PLAN REVIEW SHEET

Date:	05/16/2008	Staff Contact:	David McDonald
Petitioner:	William T. Brandon	Telephone:	704-336-6900
Petition:	2008-083	Fax:	704-432-1277
		Email:	dmcdonald@ci.charlotte.nc.us
		Attachments:	WP_Only_w_PS_60.01A.pdf
Location:	Approx. 1.34 acres on NE Corner of The Plaza and Barrington Dr.		
Existing Zoning:	R-4		
Requested Zoning:	INST(CD) To be able to provide for more children at this location.

FIRST SUBMITTAL

EXISTING SITE PLAN

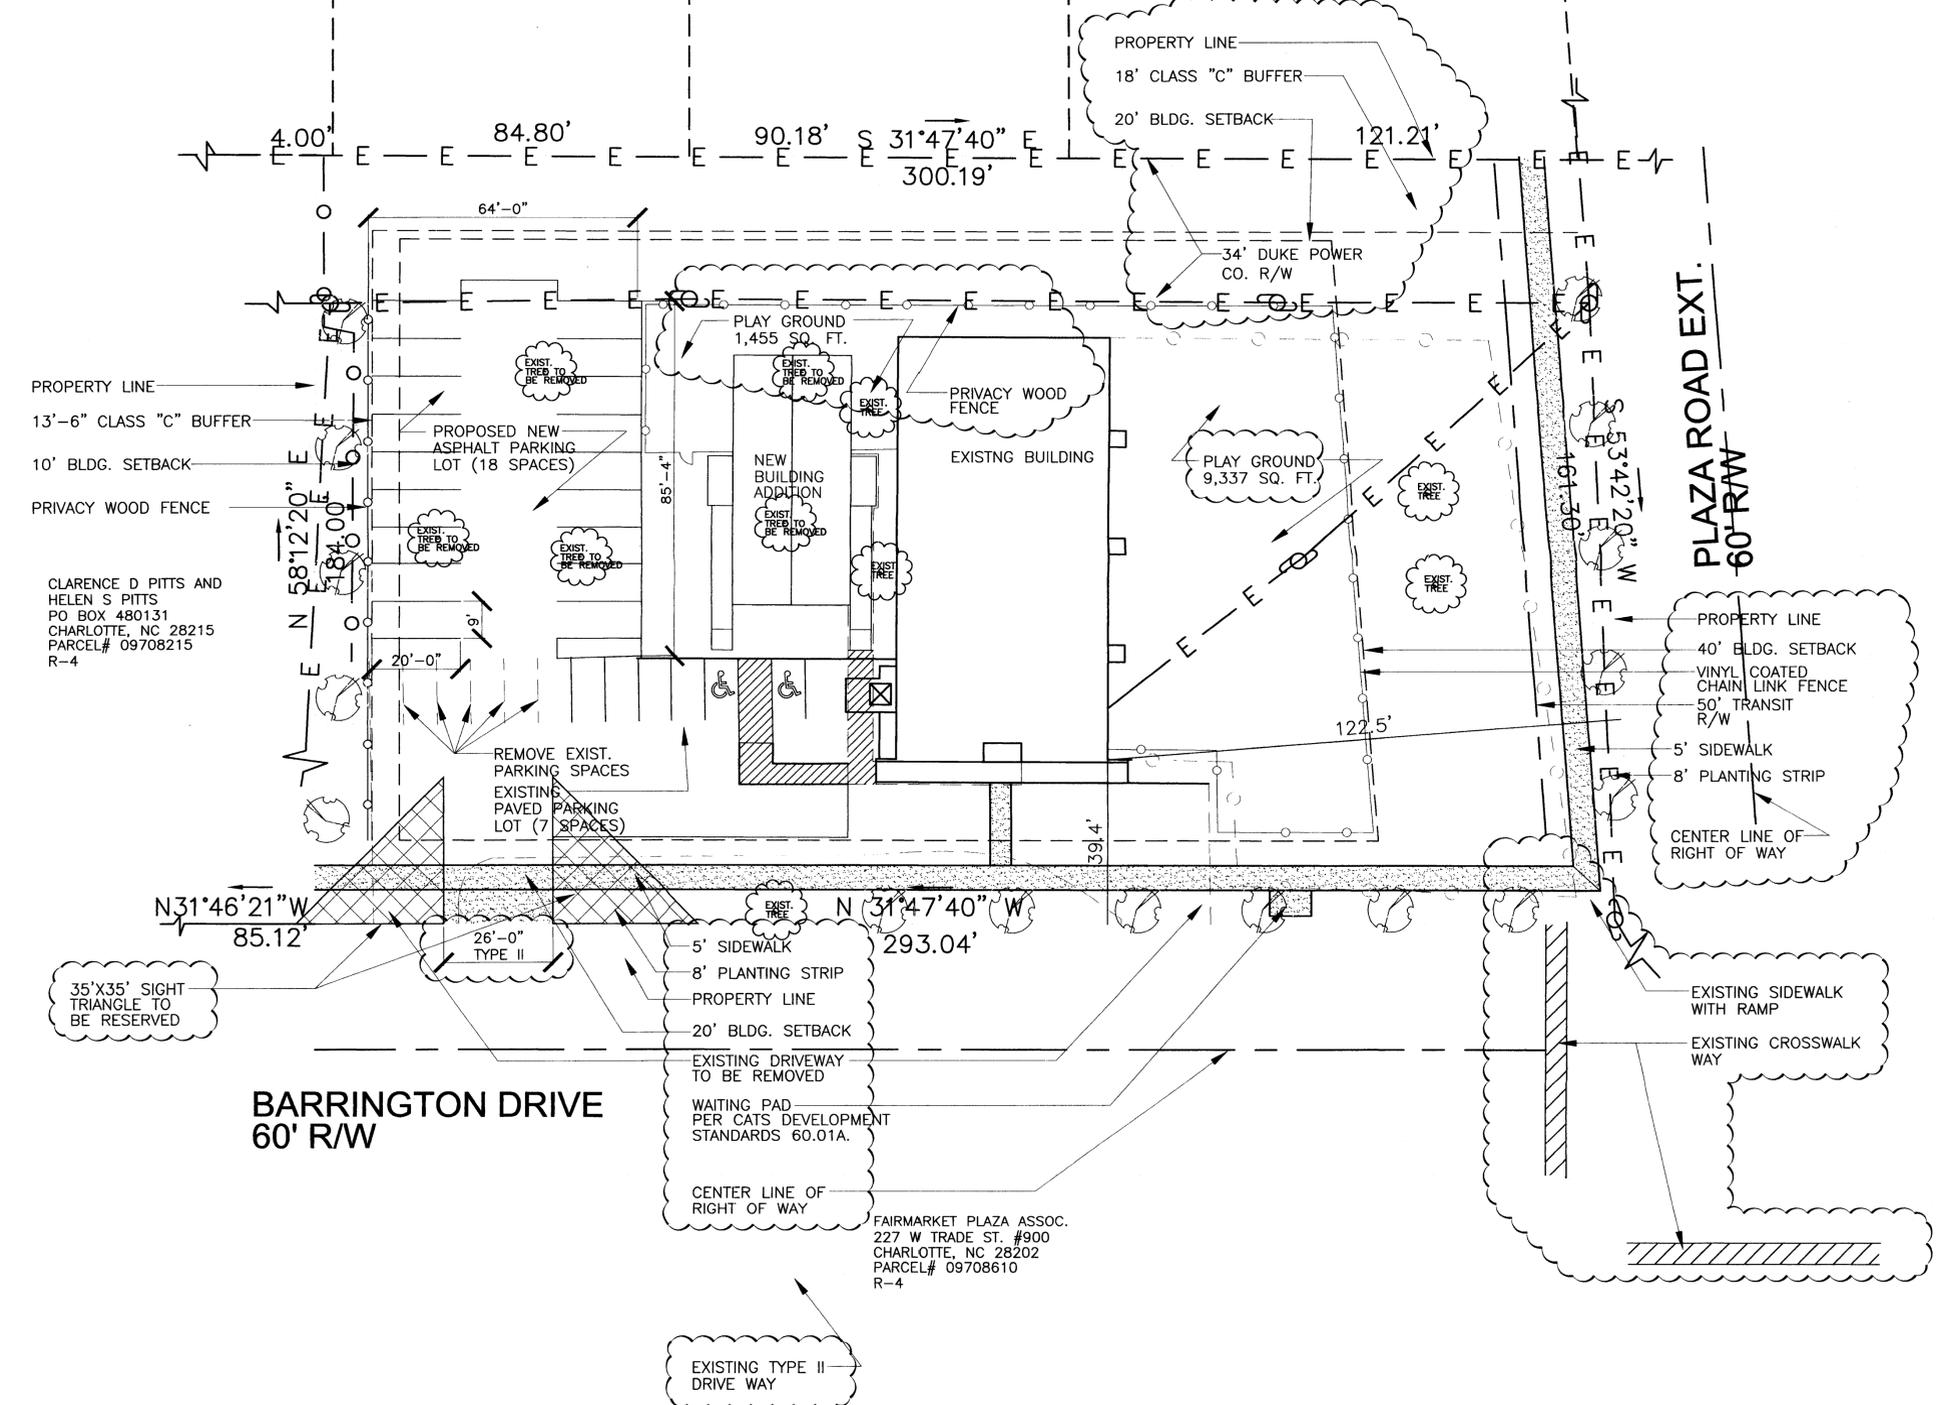
- 1) **The petitioner's site is currently served by CATS Route 3: Plaza Road.**
- 2) **CATS requests a waiting pad to be constructed on Barrington Drive. The waiting pad should be located approximately 60' from the intersection of Barrington Drive and The Plaza constructed to CATS Development Standards 60.01 A (see attached).**

A waiting pad is the connecting piece of concrete which is installed from the back of curb through the planting strip to the sidewalk (see attached). The waiting pad provides an ADA accessible bus stop boarding/alighting location for CATS' passengers.

Please designate such in the site plan and/or accompanying notes. Please contact Leonard Ganther (CATS Operations) @ 704.432.1283 prior to demolition or construction, to coordinate the final location of the waiting pad.
